**Thames Water Utilities Limited
Cory Decarbonisation Project
Written Representation**

- 1.1 On 14 June 2024 Thames Water Utilities Limited (**TWUL**) submitted a relevant representation (**RR**) in relation to the application for development consent (**Application**) for the Cory Decarbonisation Project (**Project**) made by Cory Environmental Holdings Limited (**Applicant**).

- 1.2 This written representation is provided on behalf of TWUL by its advisors and is an update as to TWUL's position on the issues raised in the RR, and also sets out TWUL's additional concerns with the proposed Project, following further assessment of the Application documents, the Applicant's responses to date and attendance at the initial examination hearings held between 5 and 7 November 2024.

Revision A

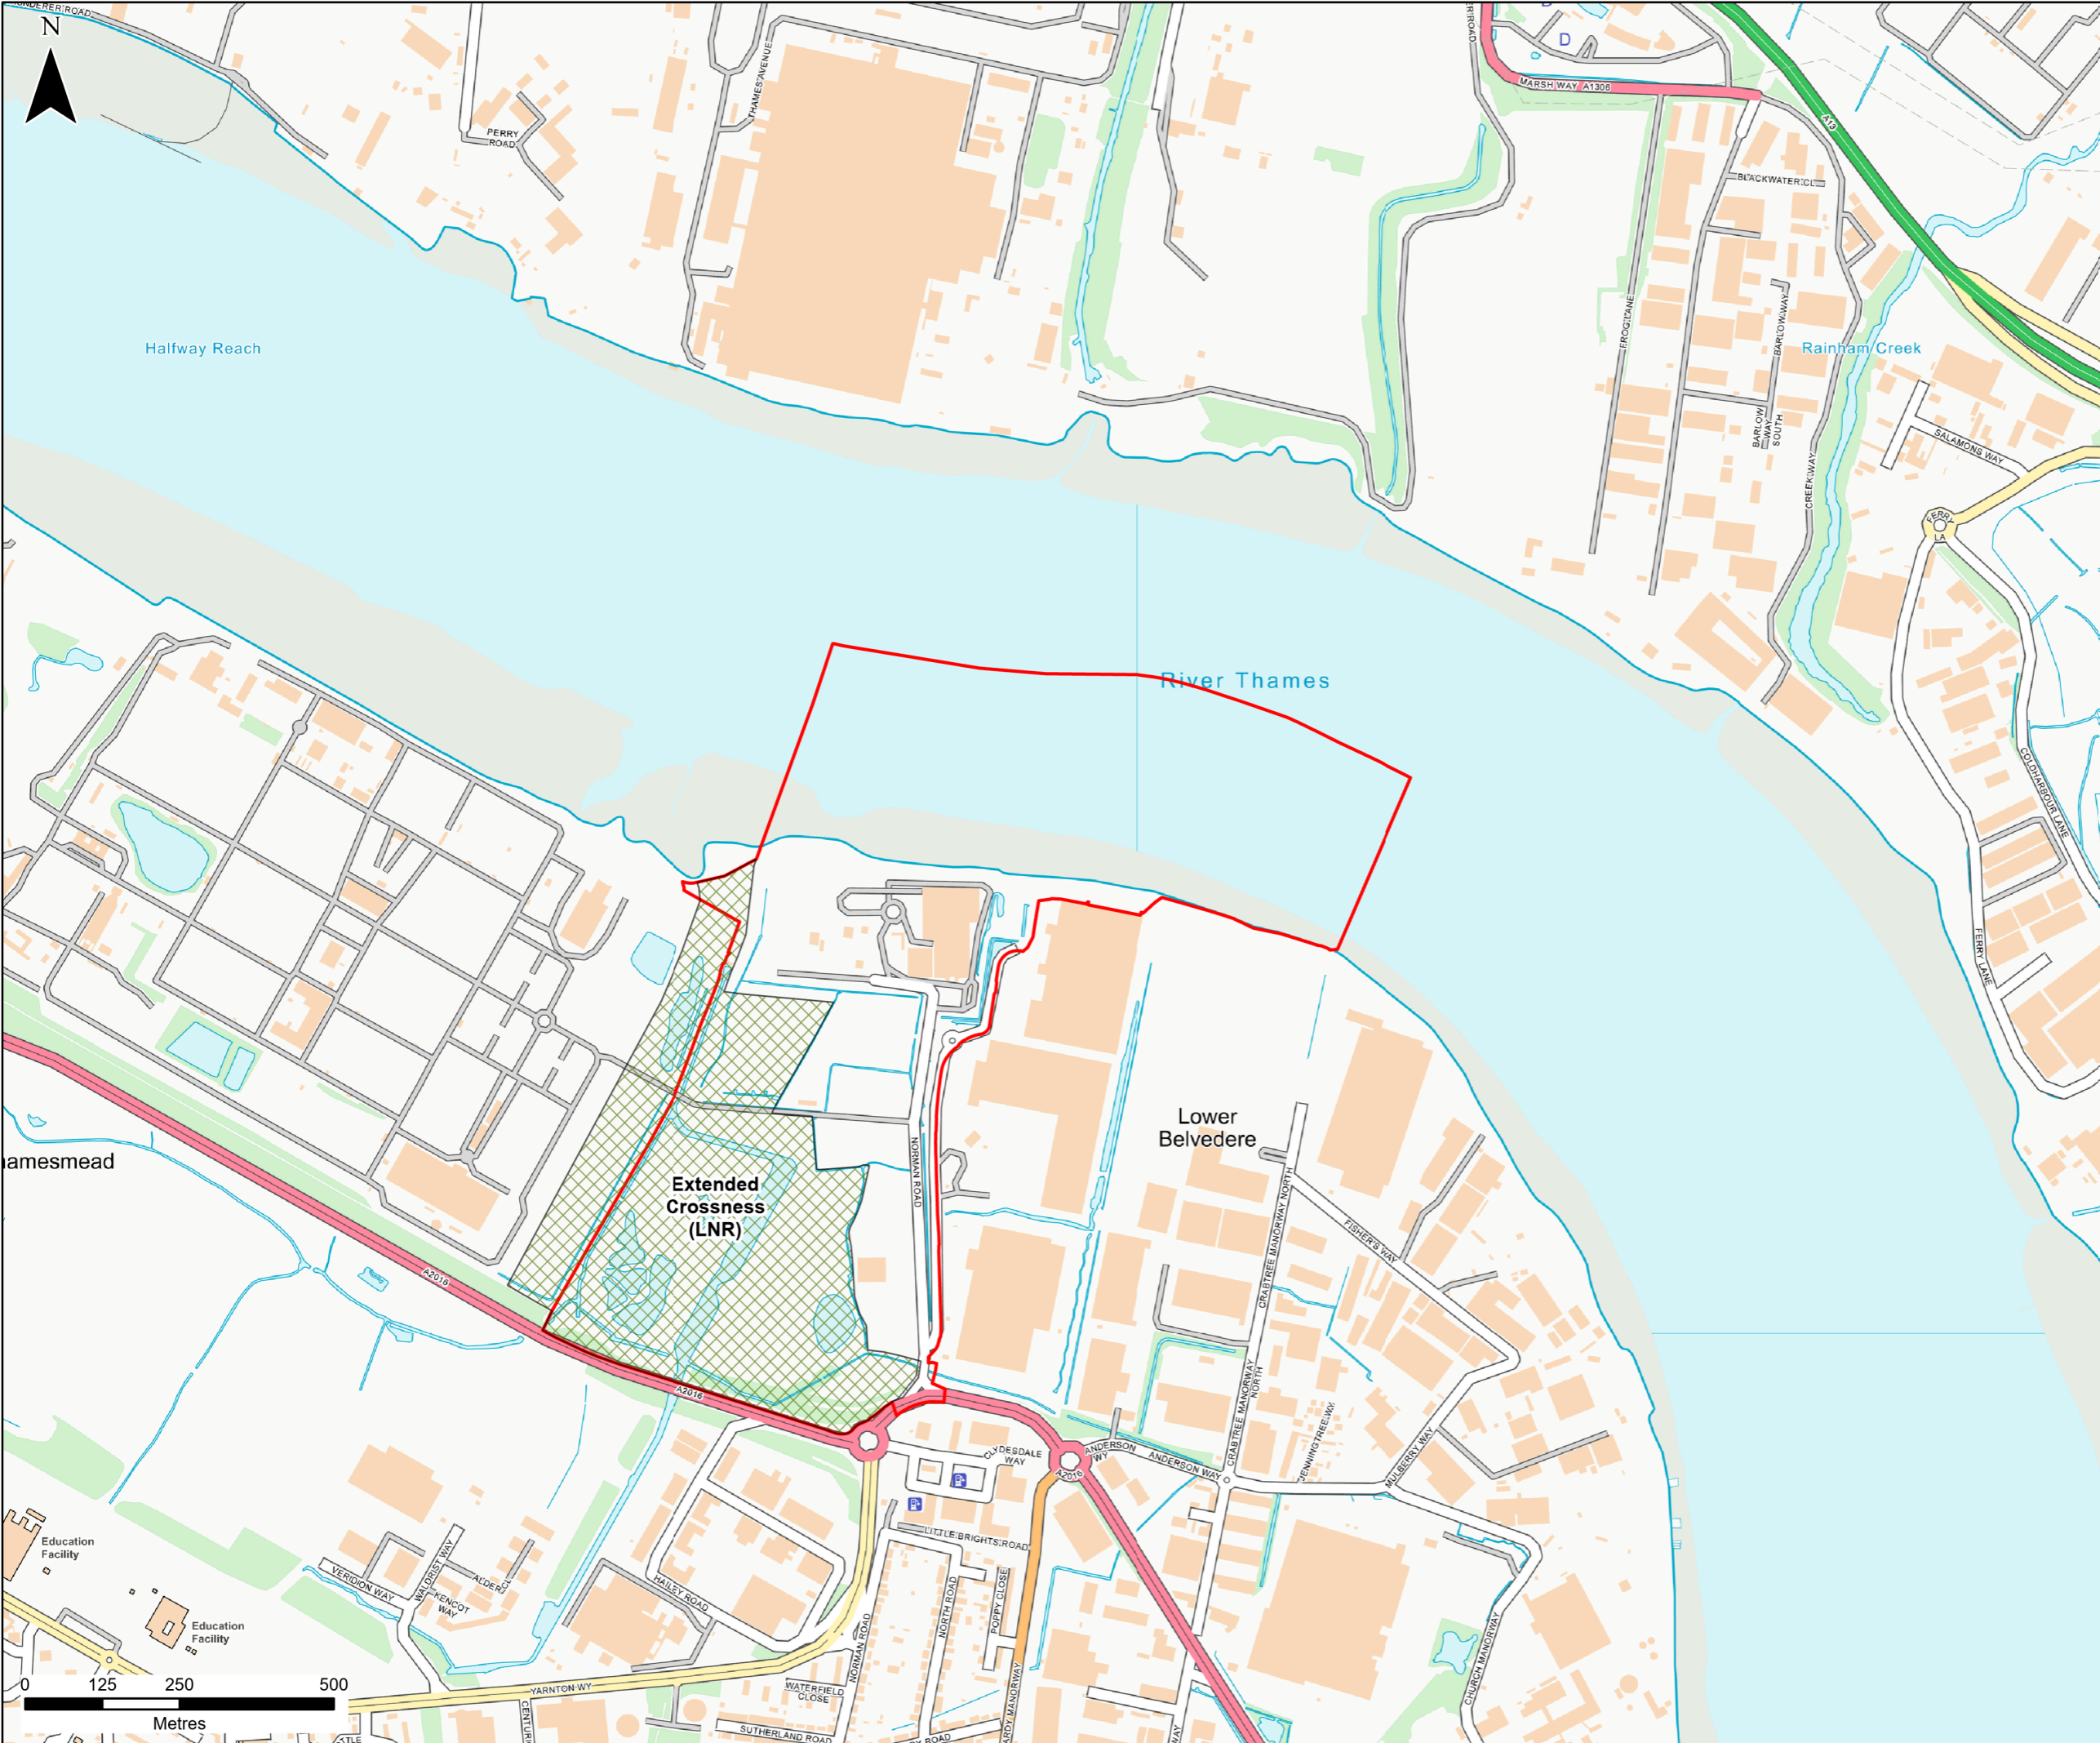
- 2.46 As to taking into account proposals to provide 'new, improved or compensatory land', the Applicant places considerable weight on what it misleadingly calls the 'extended' local nature reserve.¹⁹ This is misleading in the sense that: (a) the 'extension' (the Norman Road Field) is already subject to section 106 obligations relating to ecology and nature conservation; and (b) there is an overall net loss of open space.

Revision Number	By	Date
0100444/002		
Project Number	Project Name	Project Location

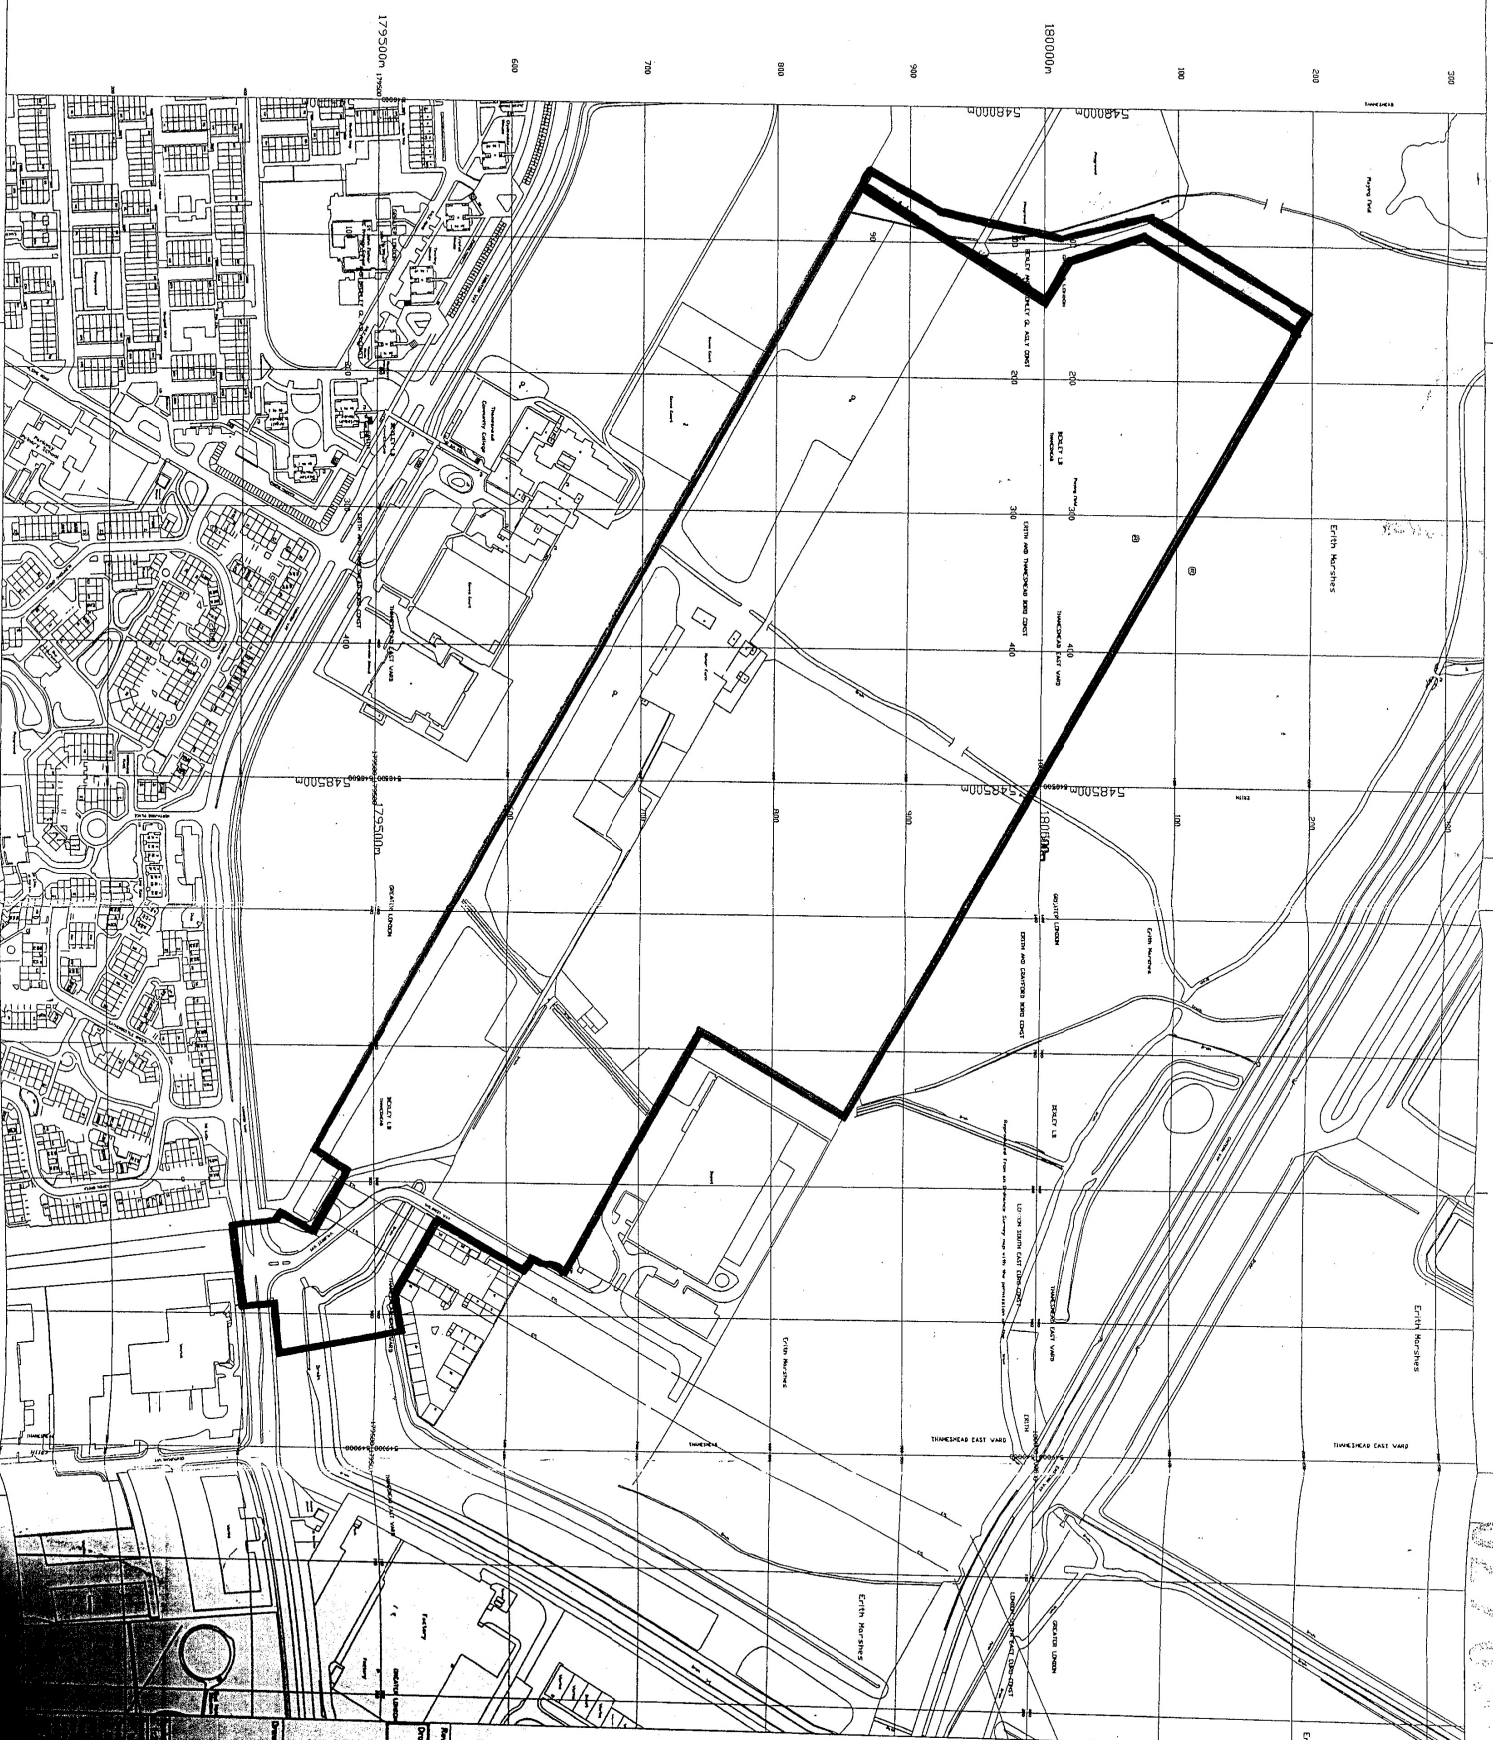
2.49 At clause 2.6, "Area 5" is defined as meaning: "the area within the Site so identified in the [EMP]". Drawing number D100444/001, attached to the EMP and entitled 'Figure 1 Ecological Master Plan Study Areas' identifies Area 5 in blue, being the Norman Road Field.

2.50 Section 5.3 of the EMP ('Grazing marsh grassland') sets out the management proposals for Area 5 (i.e. what is required to comply with clause 24 of the 2005 Agreement, including:
